**KIRKLEES METROPOLITAN COUNCIL
INVESTMENT & REGENERATION SERVICE**

Reference No:	2025/62/90753/W
Site Address:	50, Birkby Lodge Road, Birkby, Huddersfield, HD2 2BG
Description:	Removal of stone pillars (within a Conservation Area)
Recommending Officer:	Joshua Merriman

Officer Report – 2025/90753

REV	DESCRIPTION	DATE	DRAWN
CLIENT	Mr Jamil Akhtar		
ADDRESS	50 Birkby Lodge Road HD2 2BG, Huddersfield		
PROJECT	Access Pillars		
DRAWING	Proposed Layout and Elevation		
DRAWN	UH	DATE	March 25
		SCALE	1.20@A1
DWG No.	2224/05		
STATUS	PLANNING

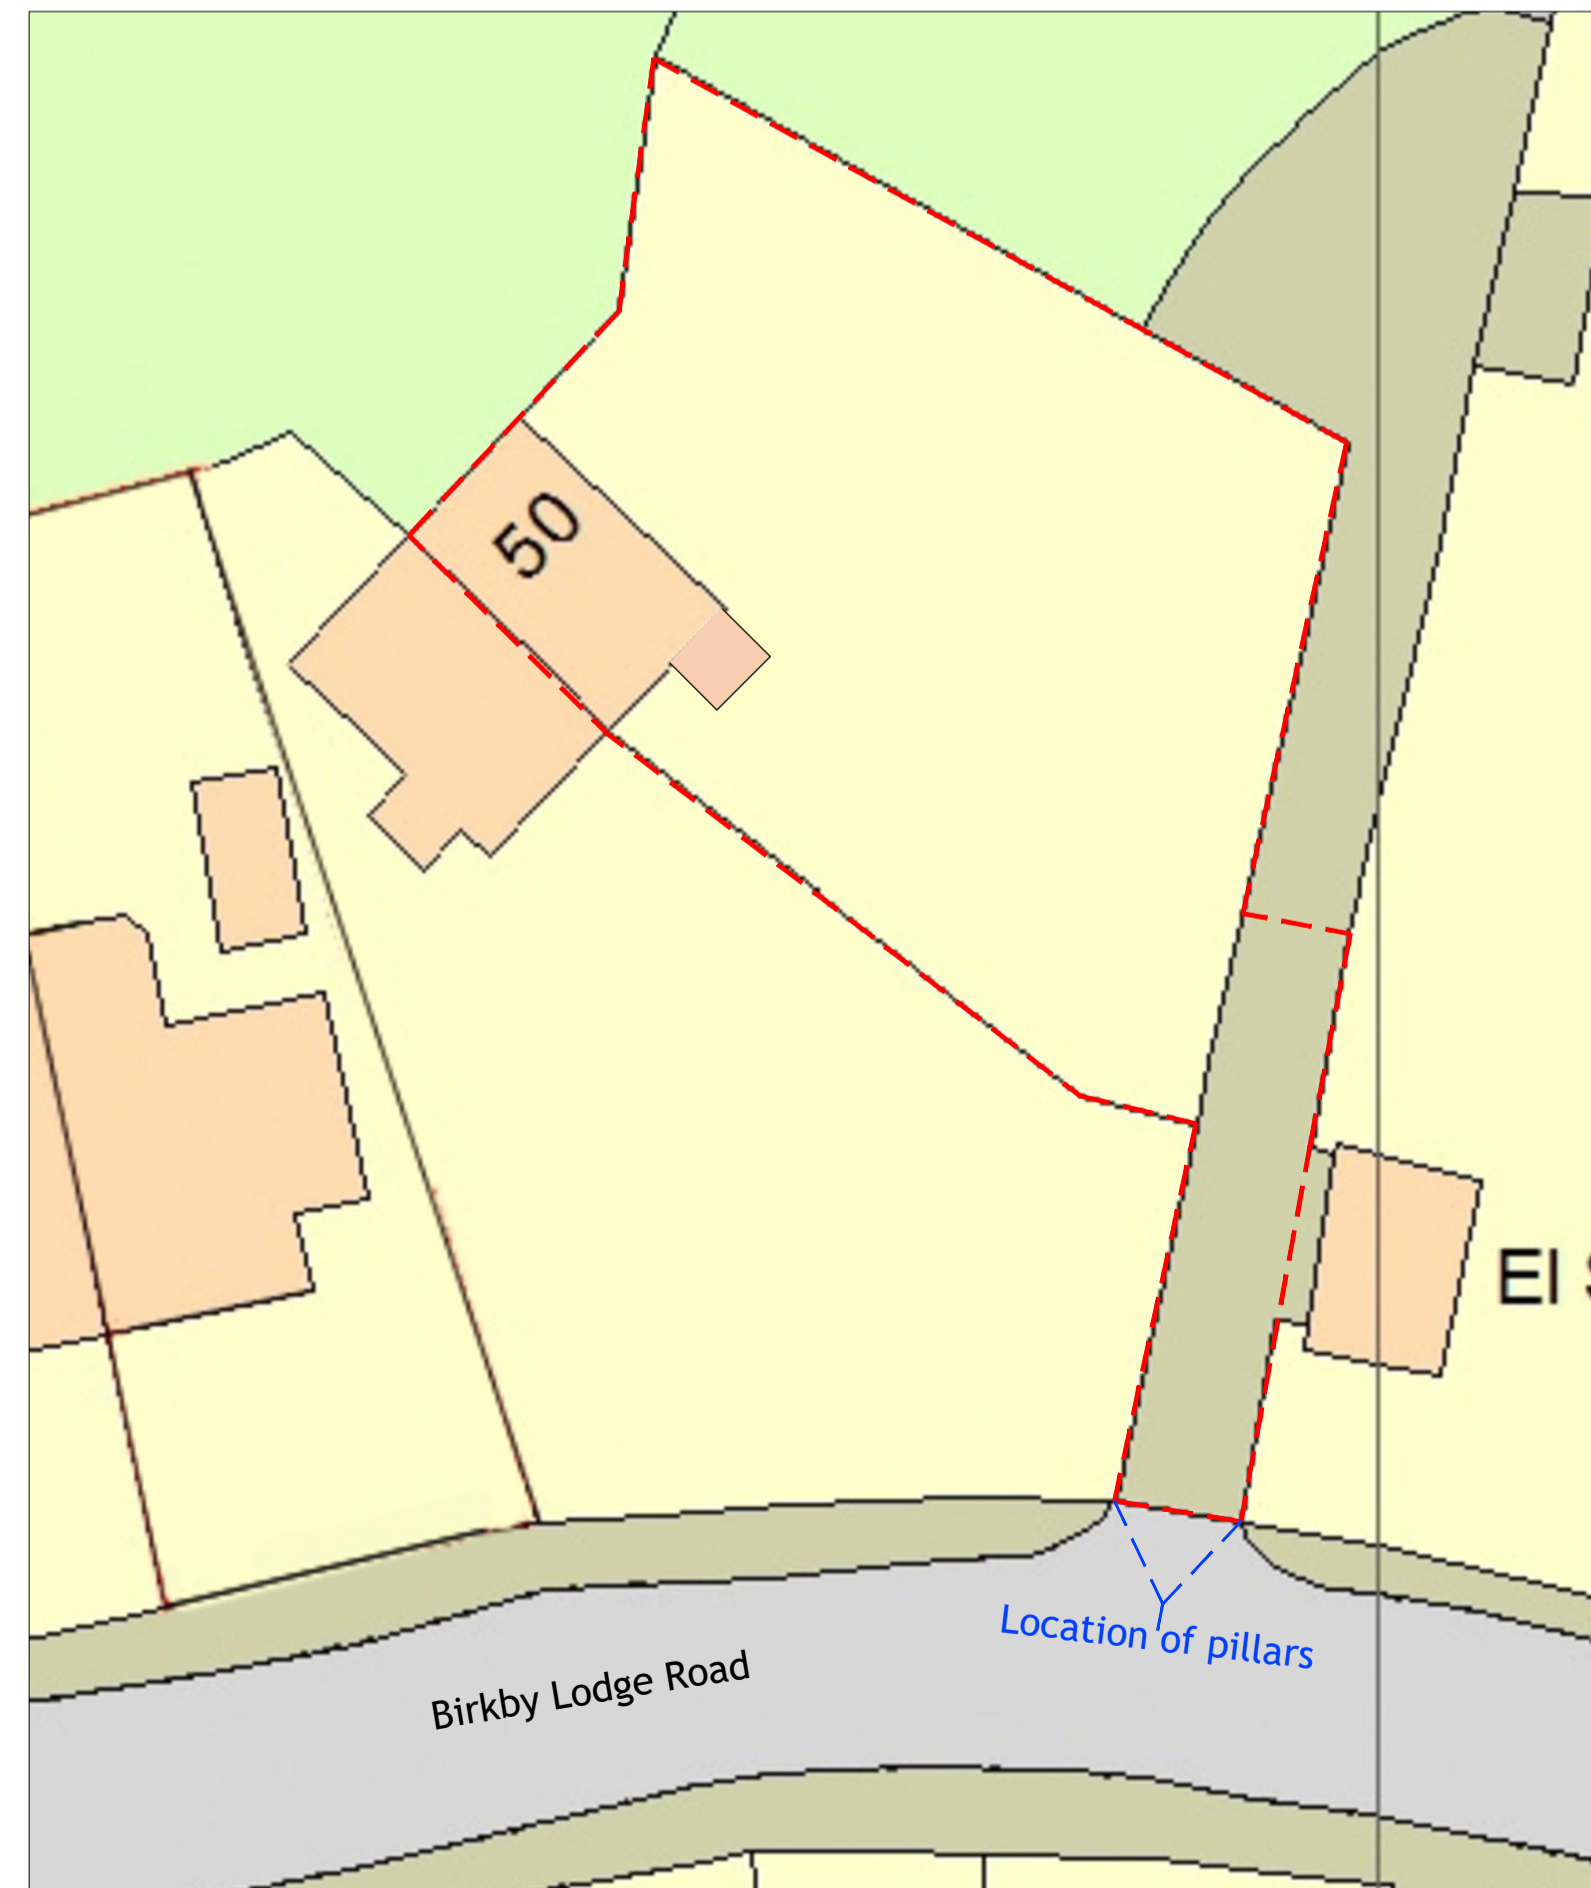
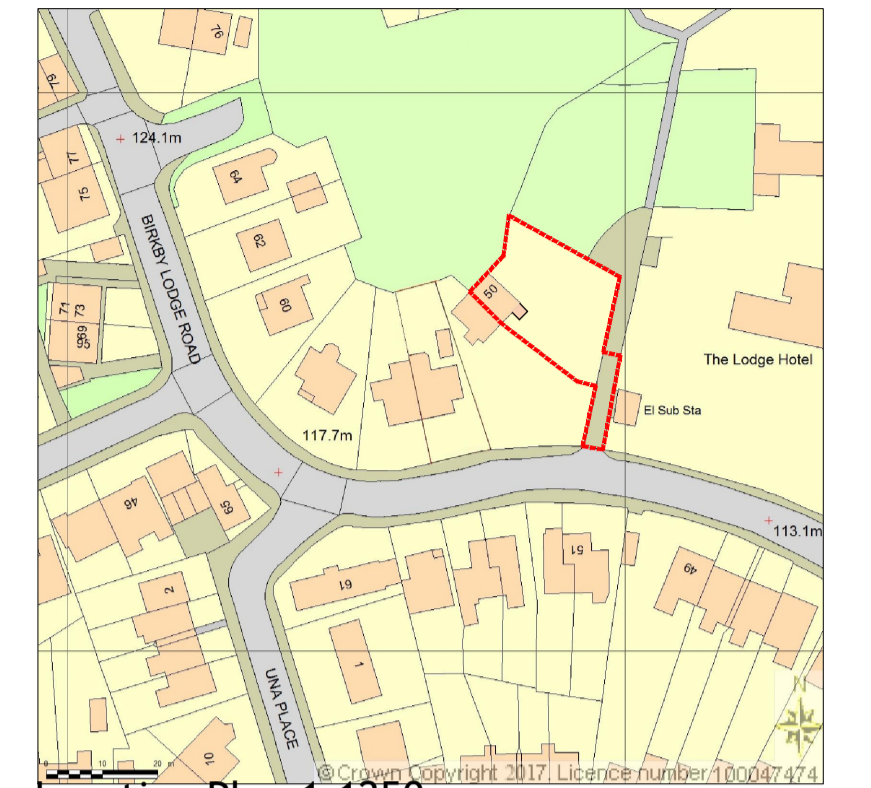
Amendments were requested regarding the ability to keep the stone pillars and re-site them, rather than remove them entirely. Following consultations with KC Conservation & Design and negotiations with the applicant, amended plans were submitted detailing the re-siting of the pillars with alterations to the boundary walls.

CLIENT	Mr Jamil Akhtar		
ADDRESS	50 Birkby Lodge Road HD2 2BG, Huddersfield		
PROJECT	Access Pillars		
DRAWING	Proposed Layout and Elevation		
DRAWN	UH	DATE	March 25
		SCALE	1.100
DWG No.	2224/06		
STATUS	PLANNING

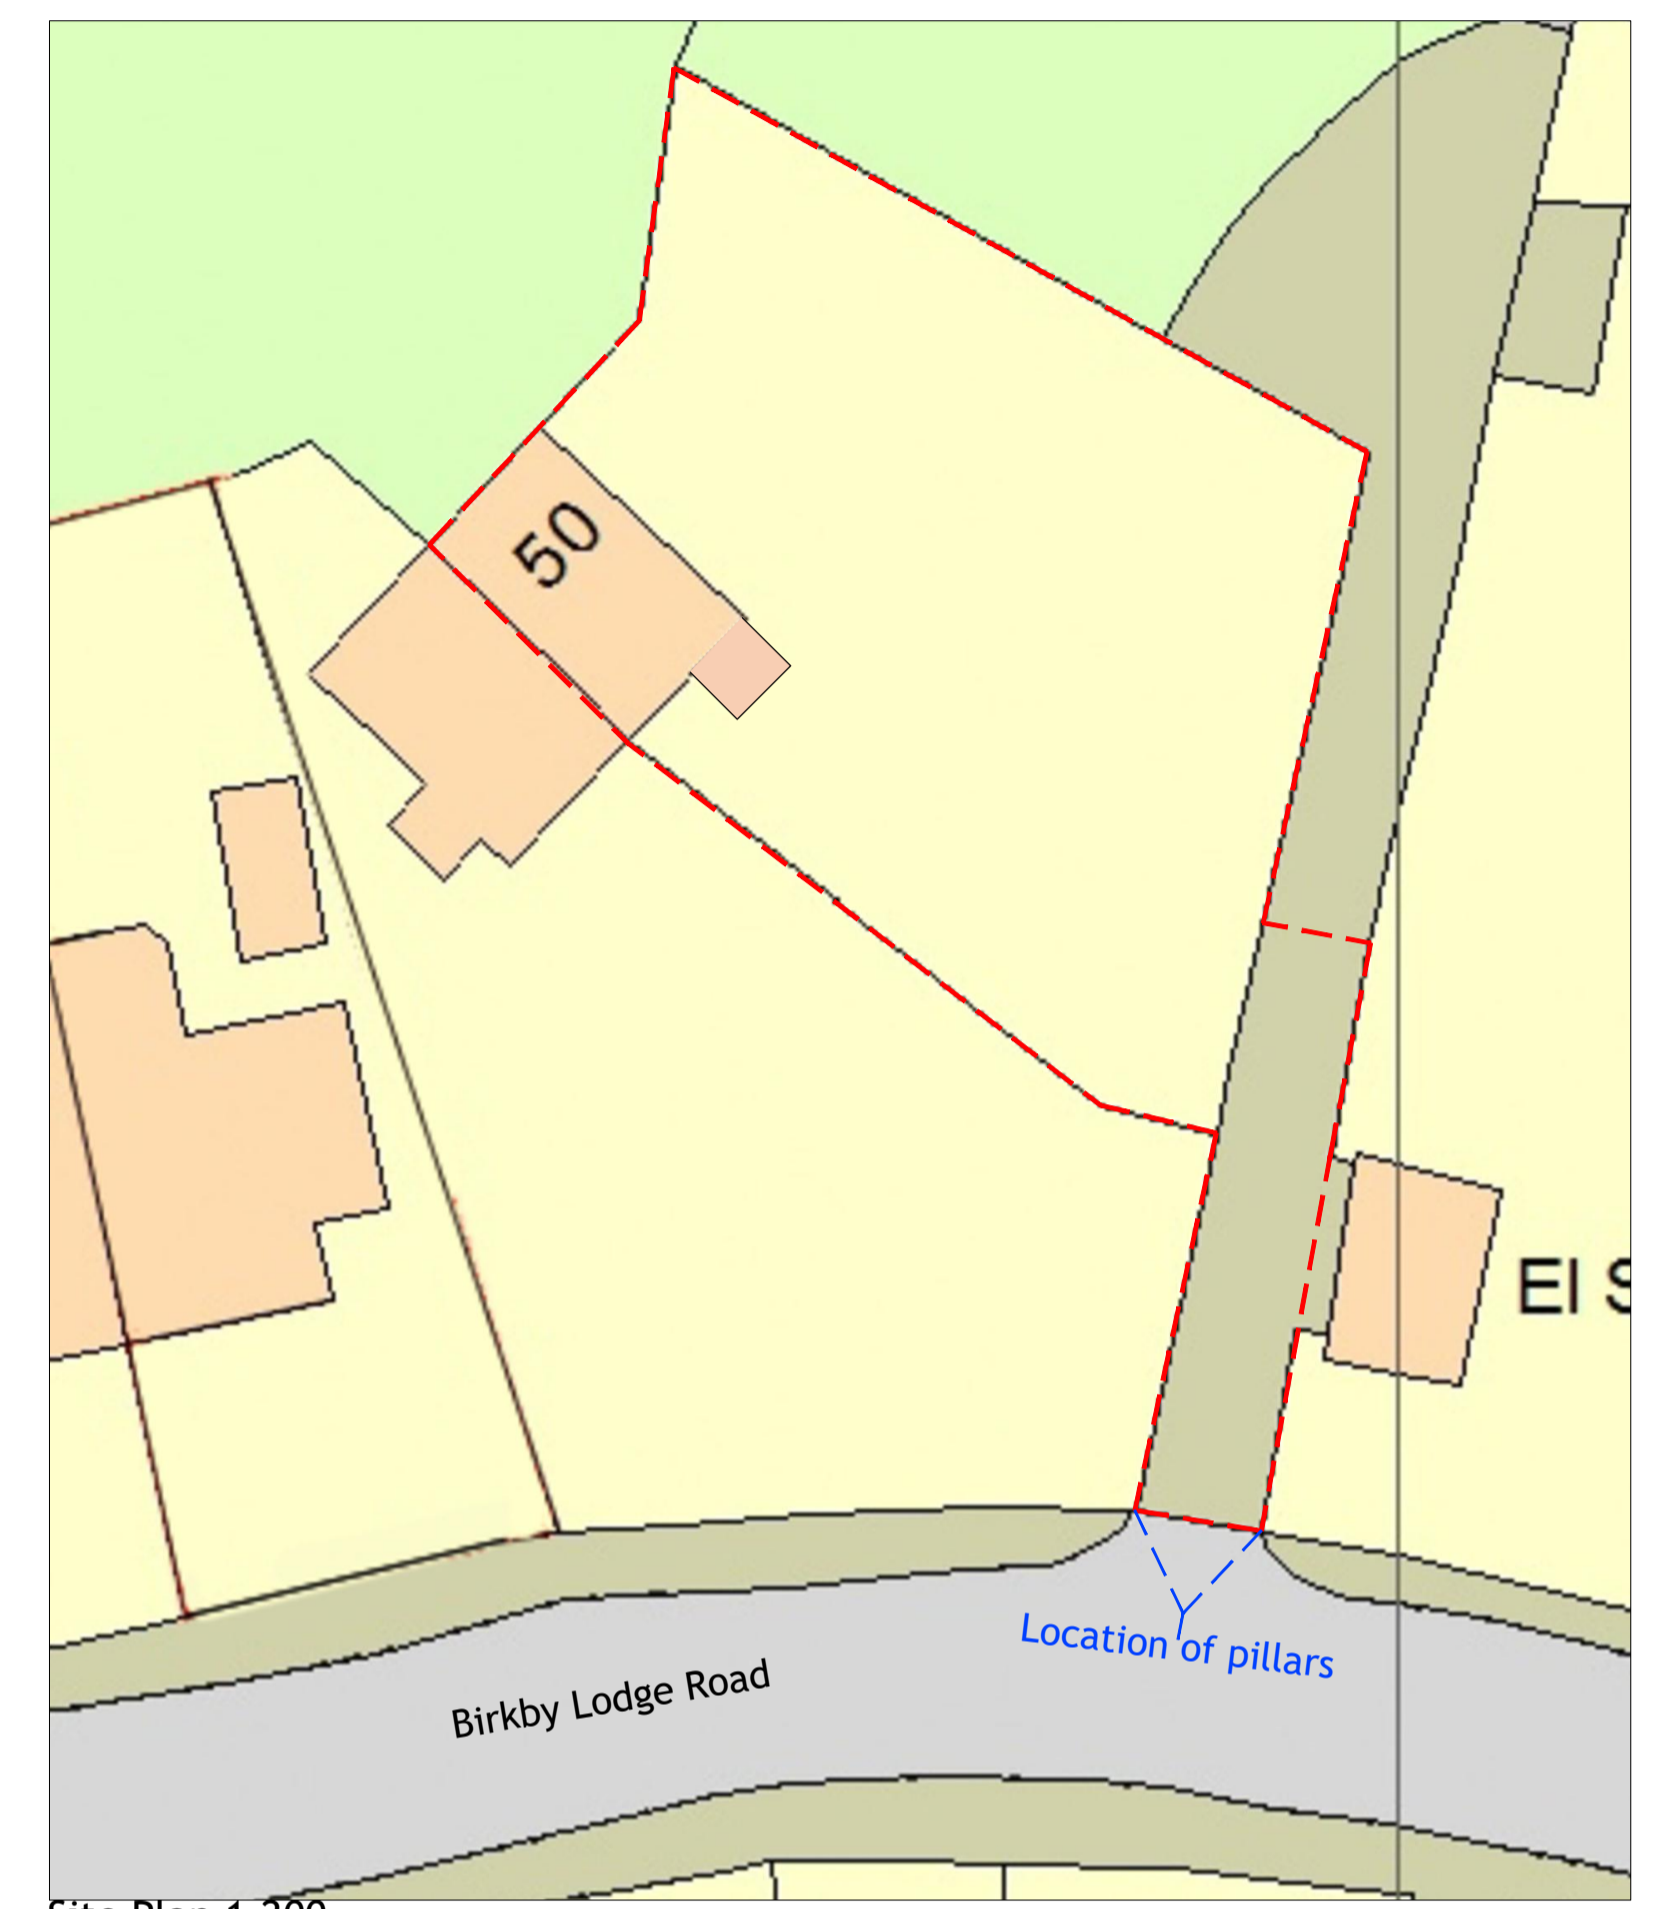
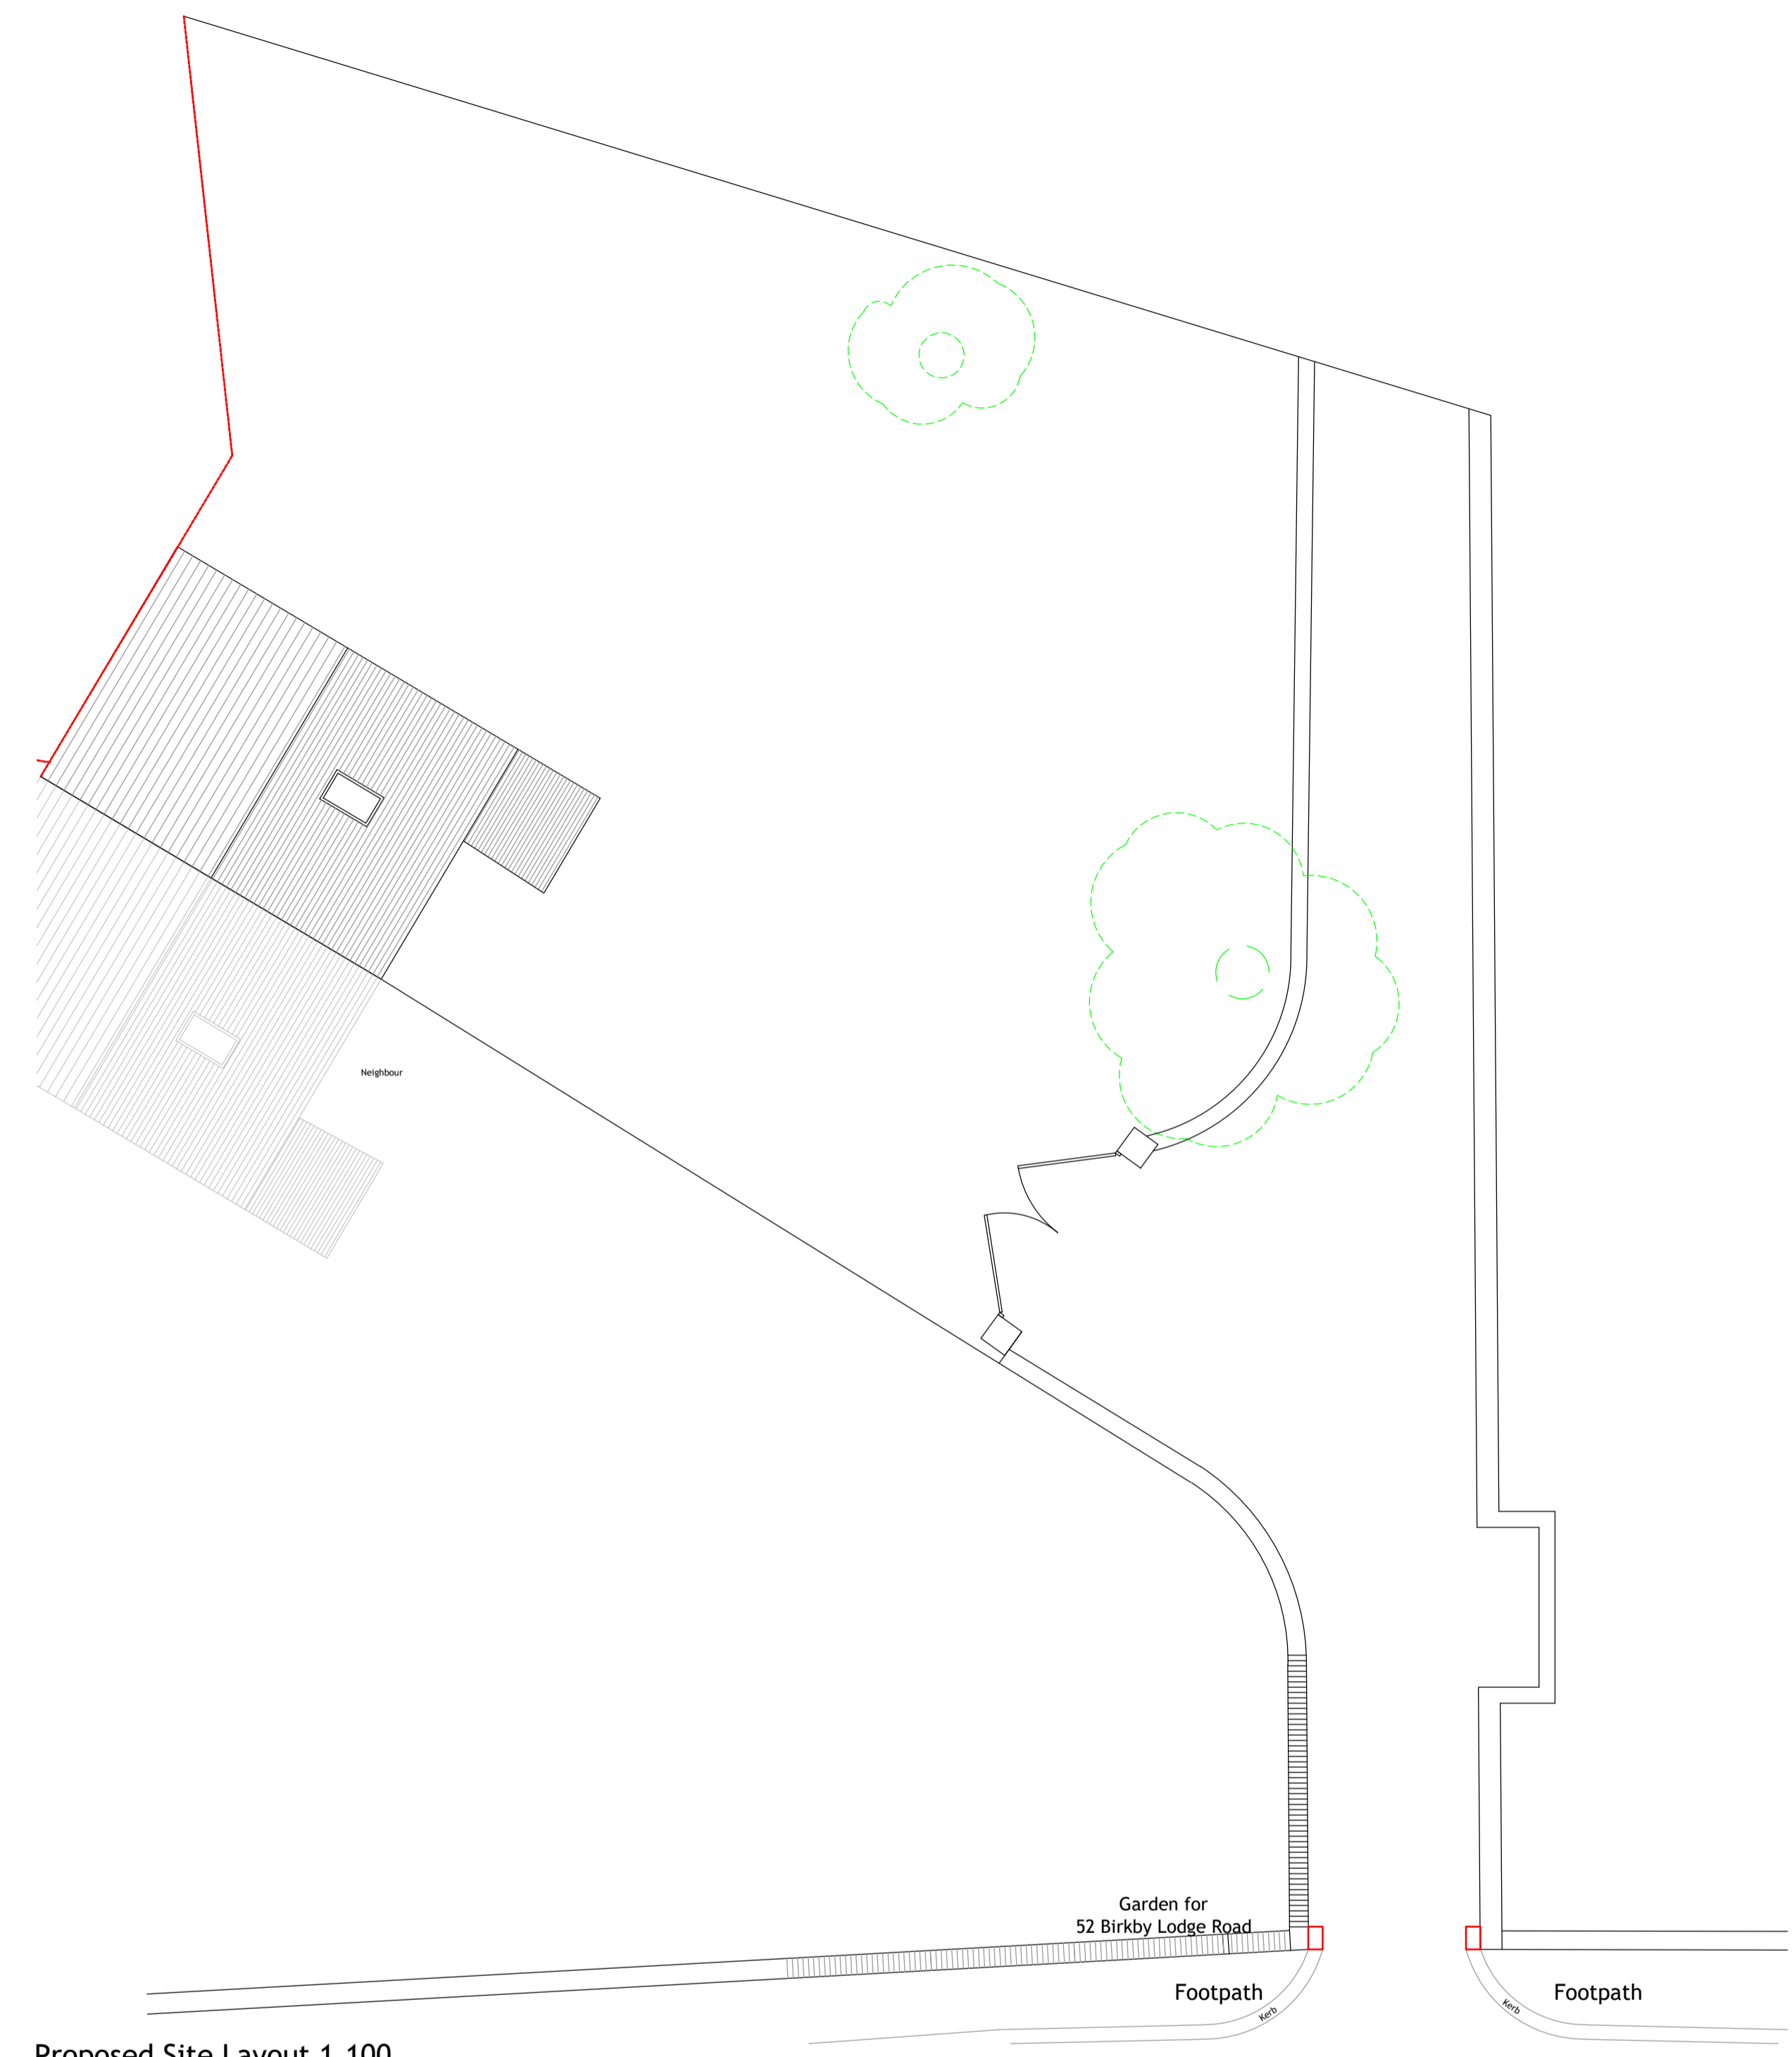
3. The rebuilding of the boundary wall and pillars detailed in submitted plan '2224 50 06' must be carried out re-using the stone gathered from the original wall which is to be re-sited.

4. The coursing, height, and finish of the re-sited wall/pillars hereby approved shall in all respects match the existing boundary wall.

5. The pointing on the re-sited wall/pillars hereby approved must be flushed or recessed and carried out using an appropriate lime mortar mix to match the colour of the stone.

6. Any copings located in the area of boundary wall/pillars that has been approved for re-siting must be retained in the replacement boundary wall/pillars.
